Drexel, Barrell & Co.

June 26, 2024

**RE: Comment Response Letter for:
Church of Jesus Christ of Latter-Day Saints (LDS)
EX241: County Wetland & ROW Land Acquisition Hwy 105 & LDS
Church – Exemption Plat Monument**

Exemption Plat

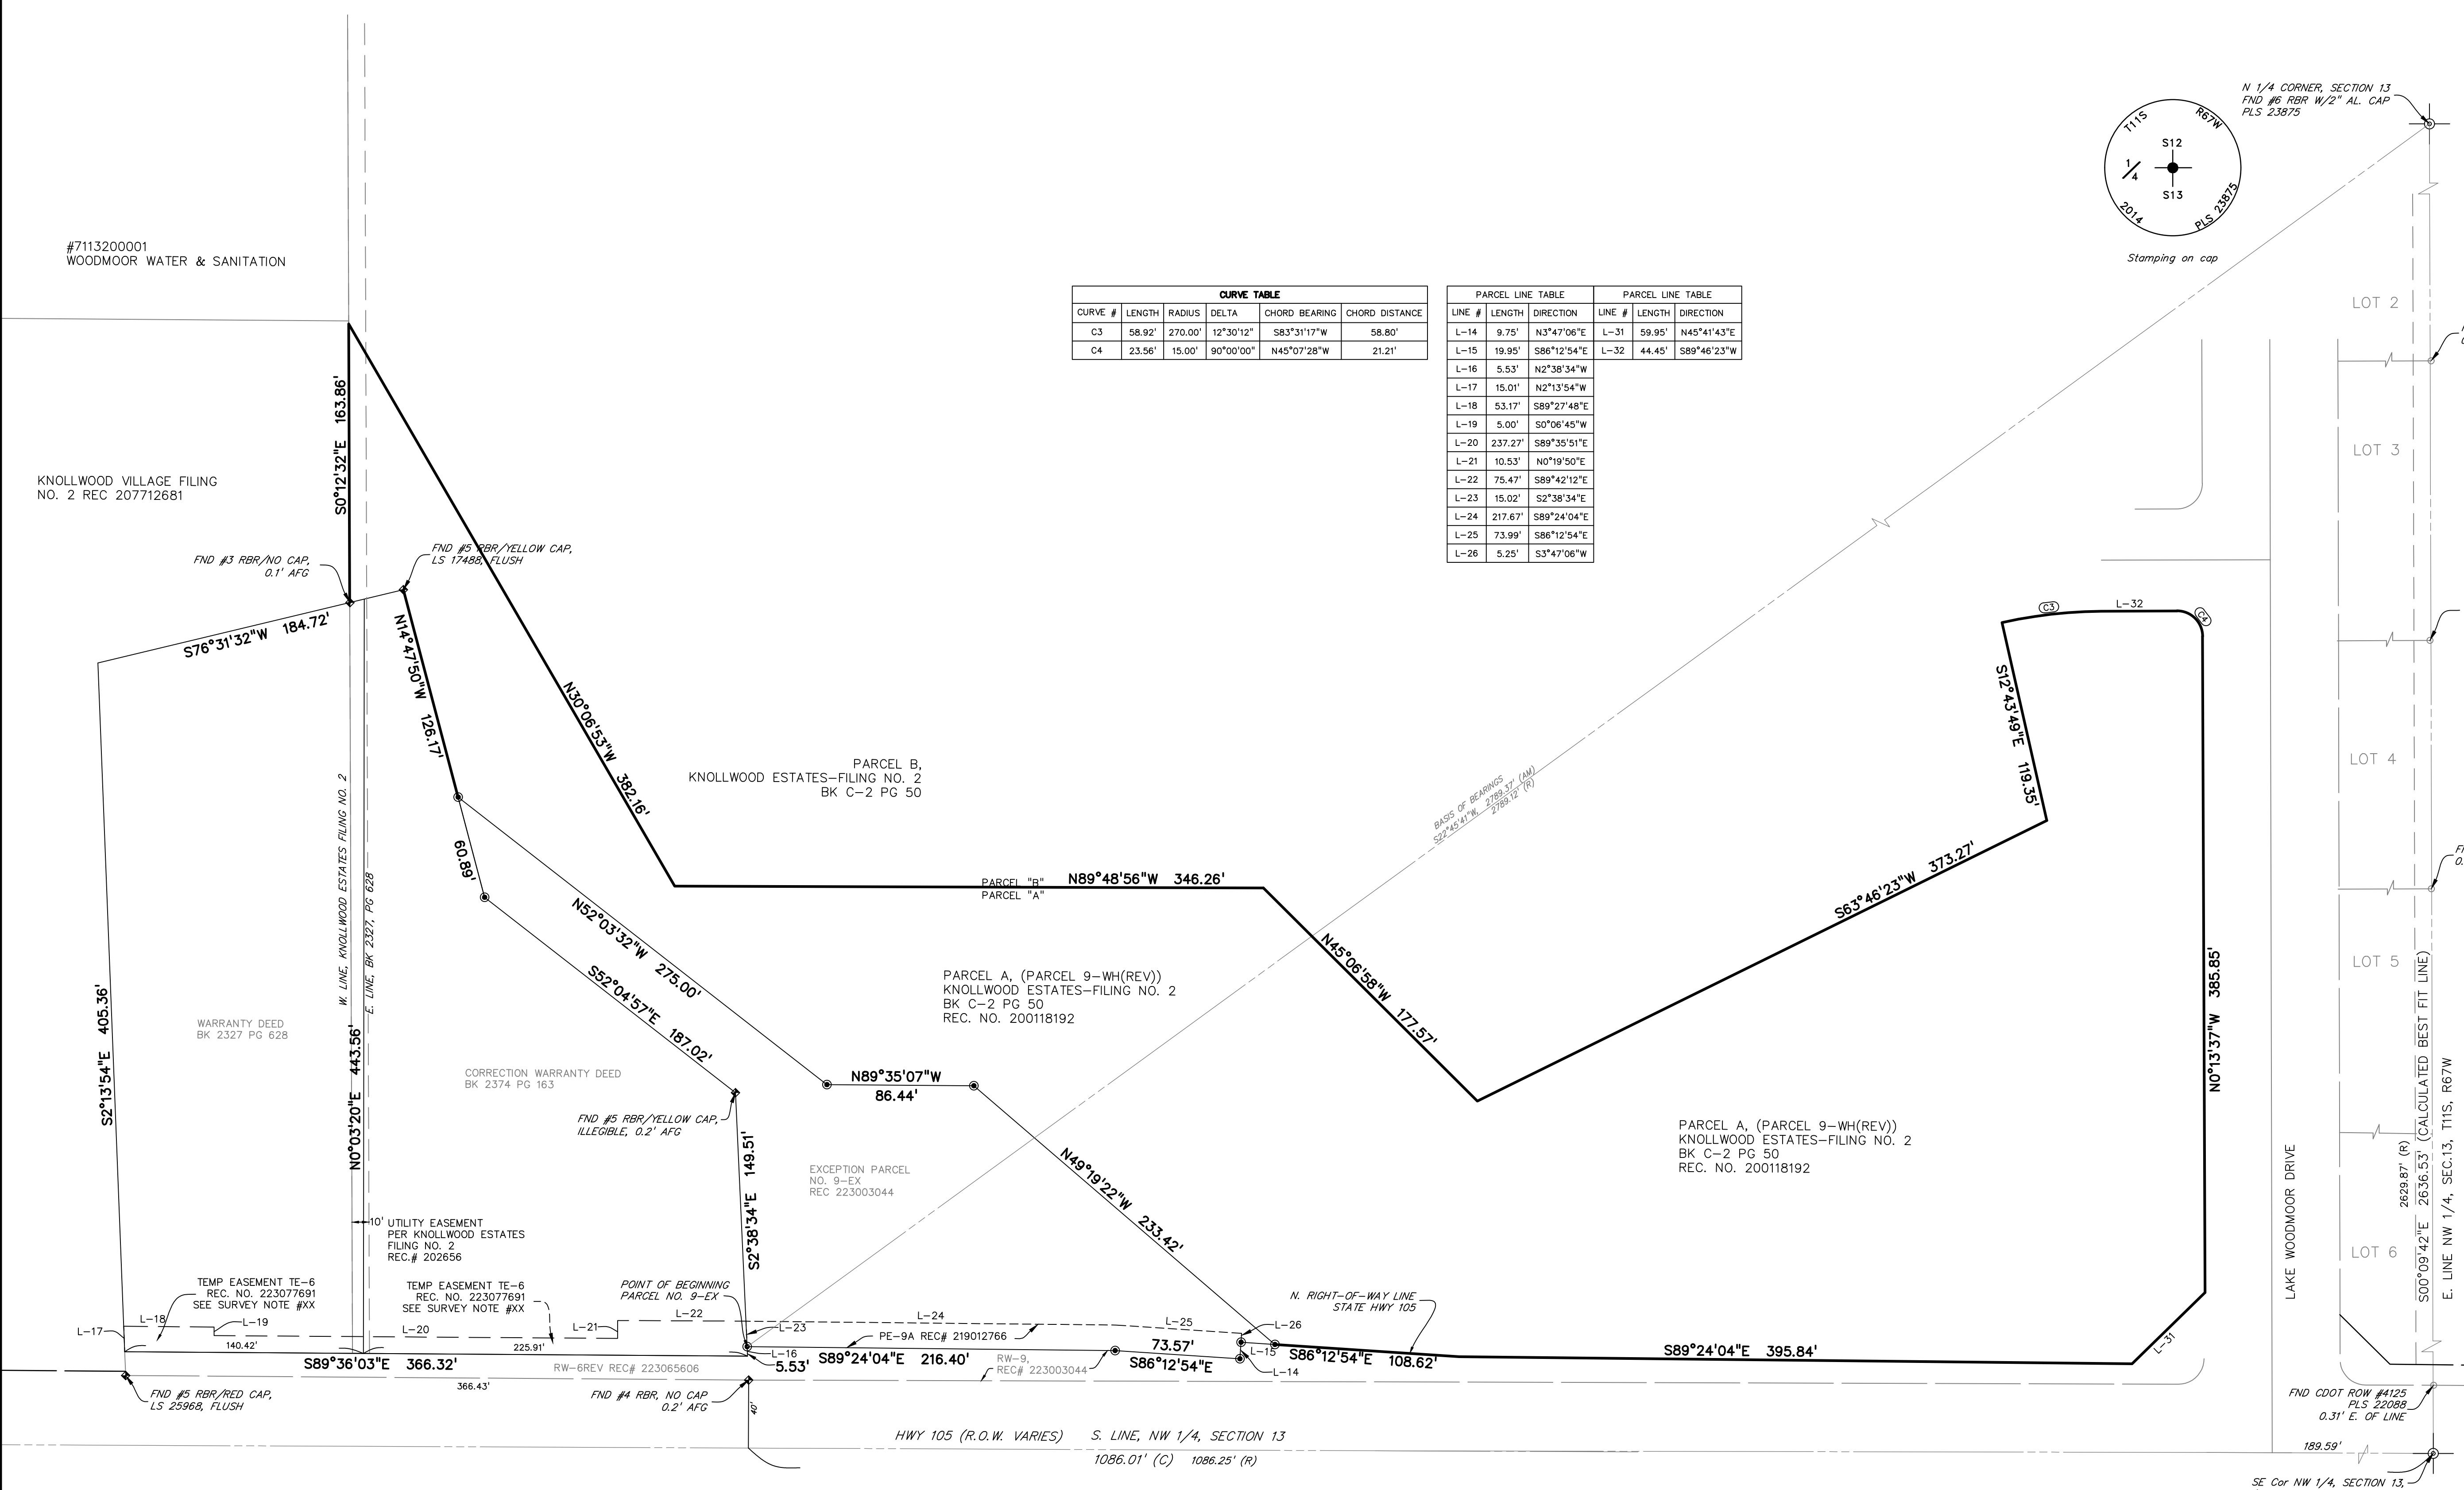
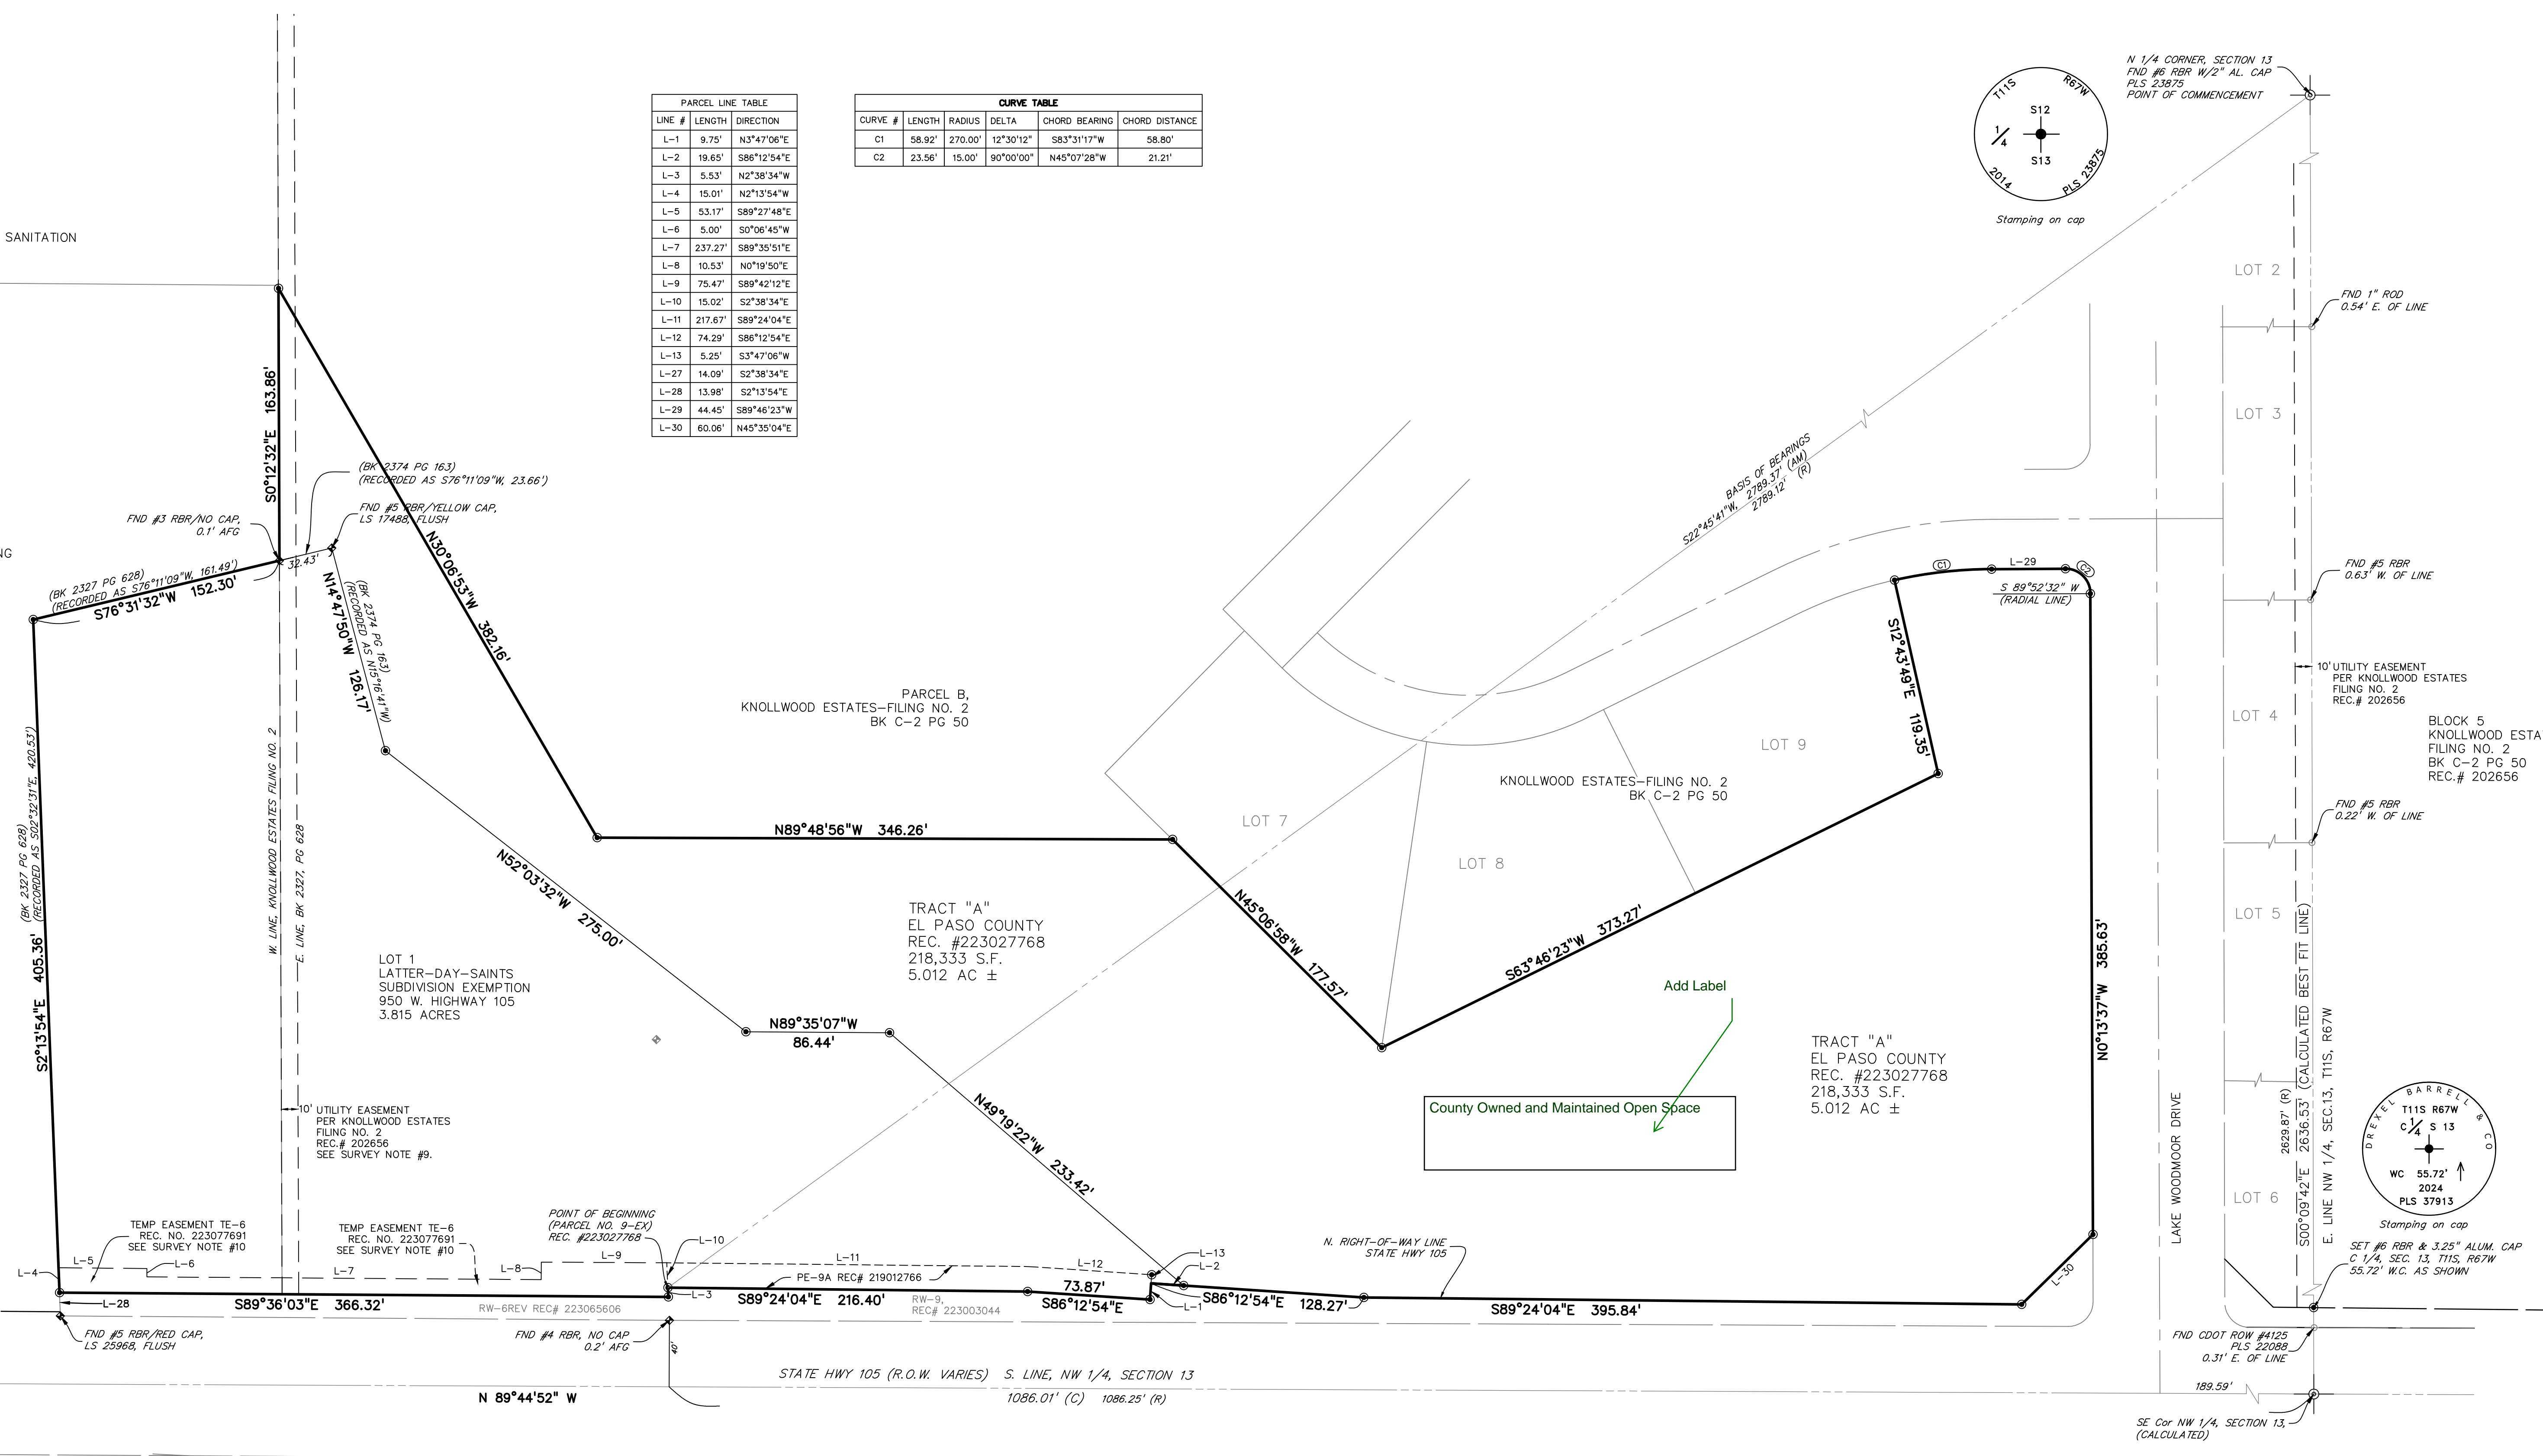
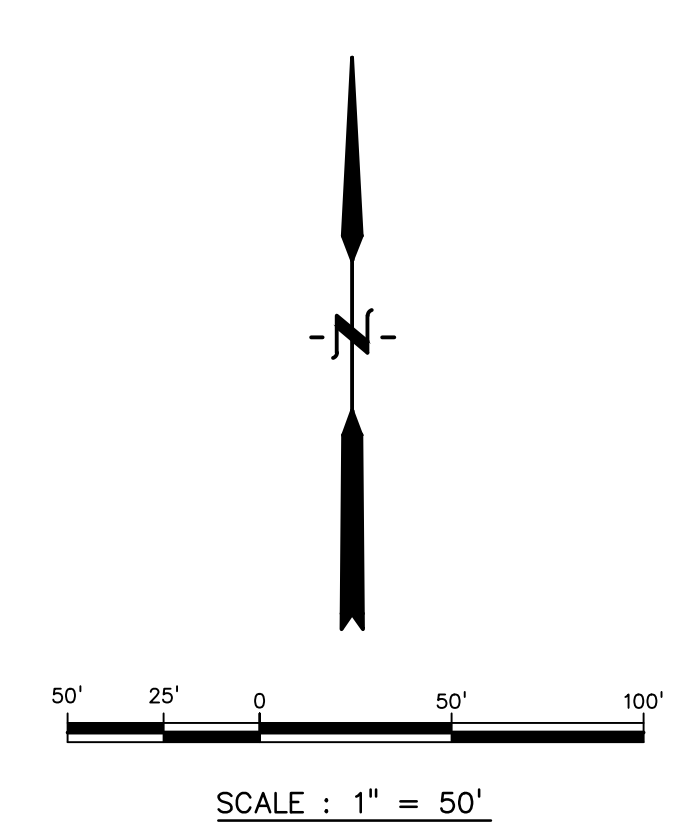
1. Letter of Intent: please address only the exemption Criteria. We do not want to mix private land use with the justification for the exemption process through Right of way and open space acquisition.
2. Subdivision Exemption Plat: see comments
3. Application Petition Form: the application shall be only for the exemption pla

Exemption Plat, comments attached.

1. Letter of Intent comments have been addressed, see enclosed.
2. Subdivision Exemption Plat comments have been addressed, see revised. Please additionally note that Tract A monuments have been encountered upon further investigation and as a result, changes to the Plat including associated existing easements are now included in the revised plans.
3. Application Petition Form comments have been addressed, see revised.

Comments have been addressed and Exemption Plat revisions are included.
